Date: 10/29/2025

Re: Framing Issue

Location: Lot 24 Kipling Village (11 Saintsbury Dr. Brazan Ct. Fuquay-Varina, NC)

JDS Project No.: RDU2511110

FOUNDATION PLAN

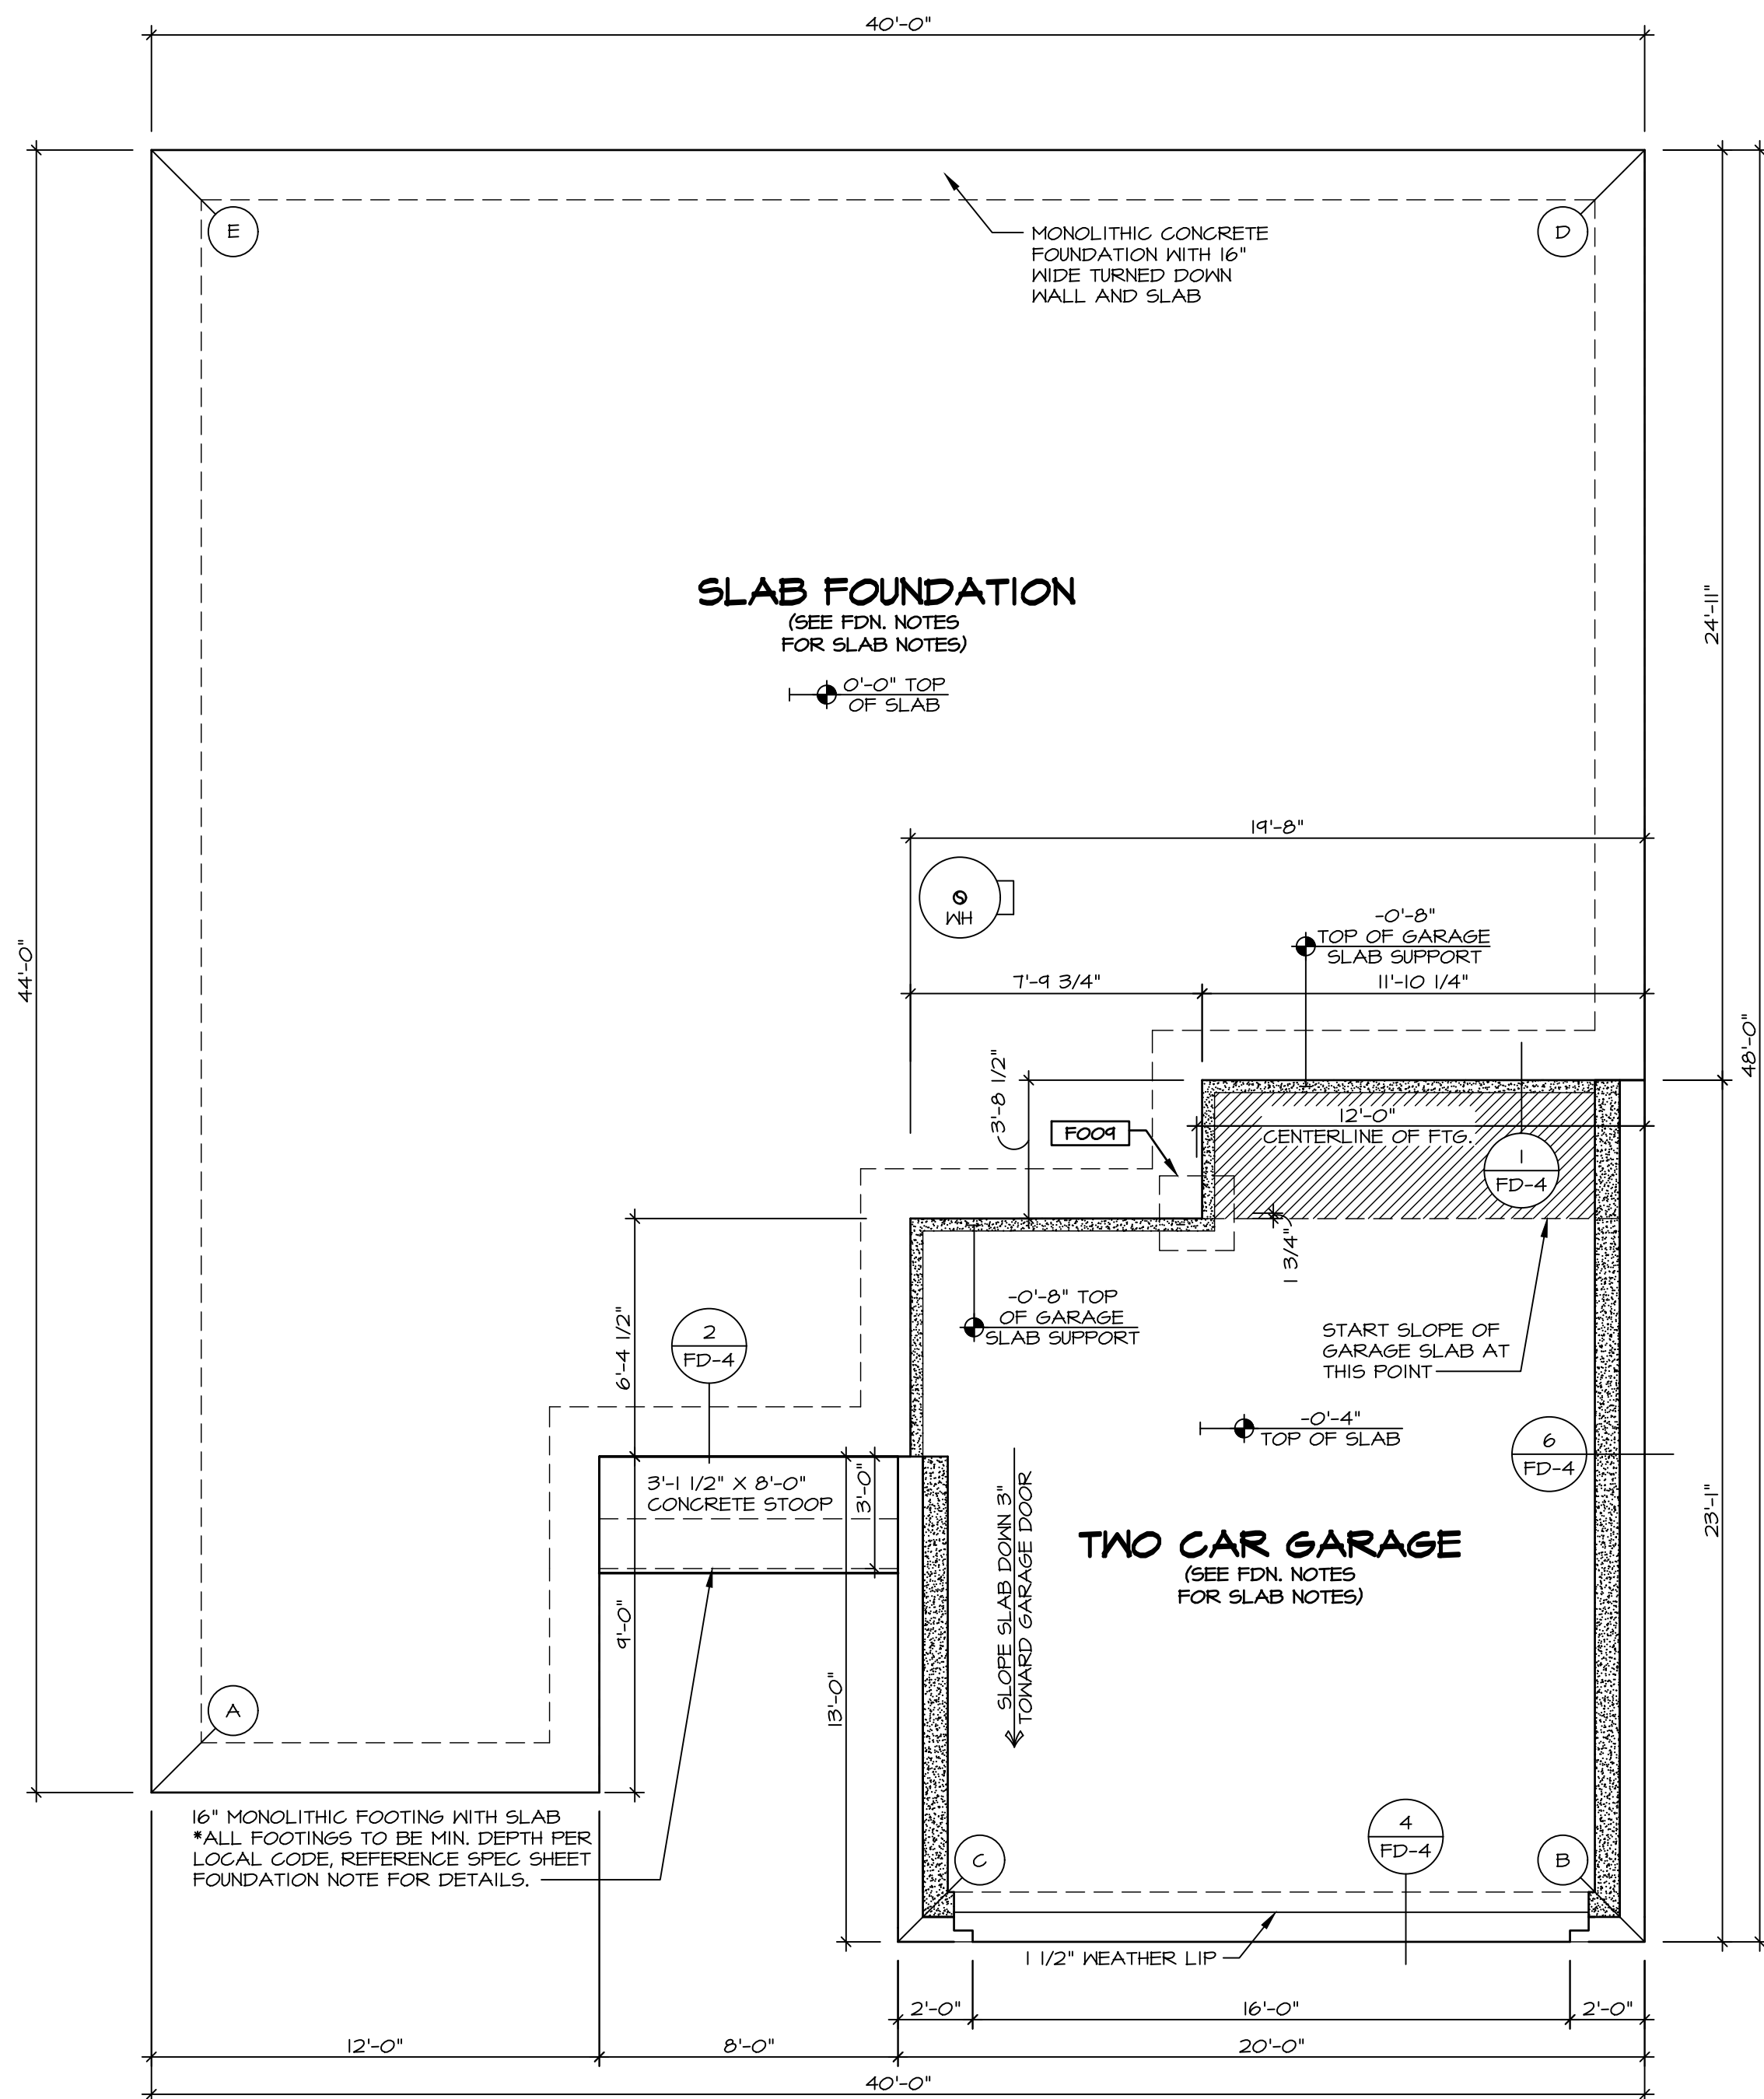
The client requested an evaluation of overhanging sill plates in the garage, observations are as follows:

1. The rear garage wall overhangs by a maximum of approximately 1-1/2". The wall is 2x4 framed.
2. The left and right sides of the garage wing walls overhang the inside edge of the curb by a maximum of approximately 1". Walls are 2x4 framed.

1. Install a pressure-treated 2x member tight under the sill plate and flush with the slab. Attach the member with (1) row of 5" Simpson titen HD anchors spaced at 16" o.c. Ensure a minimum 2-1/2" edge distance from the top of the curb.

2. Extend the slab and footing with the following steps:
 - a. Dowel and epoxy (3) equally spaced rows of #4 rebar into the cut face of the slab/turndown spaced at 12" o.c. for the entire length. Dowel holes should be cleaned with compressed air and/or wire brush. The rebar should extend at least 4" into the wall and at least 5" out of the wall. Enough structural epoxy should be used that it can be seen coming out of the hole around the rebar once it has been installed. Ensure that there is at least 3" of clear cover on all sides of the rebar.

- b. Extend the slab a minimum of 6" from the top of the slab to the bottom of the footing. NOTE: The extension will need to be flashed with Z-Flashing to prevent water intrusion if the slab is extended. Alternatively, the slab may be cut back a minimum 6" from top of the slab to bottom of the footing and extended flush with the framing. Install anchor bolts per 2018 NCRC.

- c. Before placing a minimum of 3,000 psi concrete, the client shall ensure the repair preparation has been inspected and approved. Ensure that the ground beneath the excavated area is firm and not filled with water at the time of inspection.
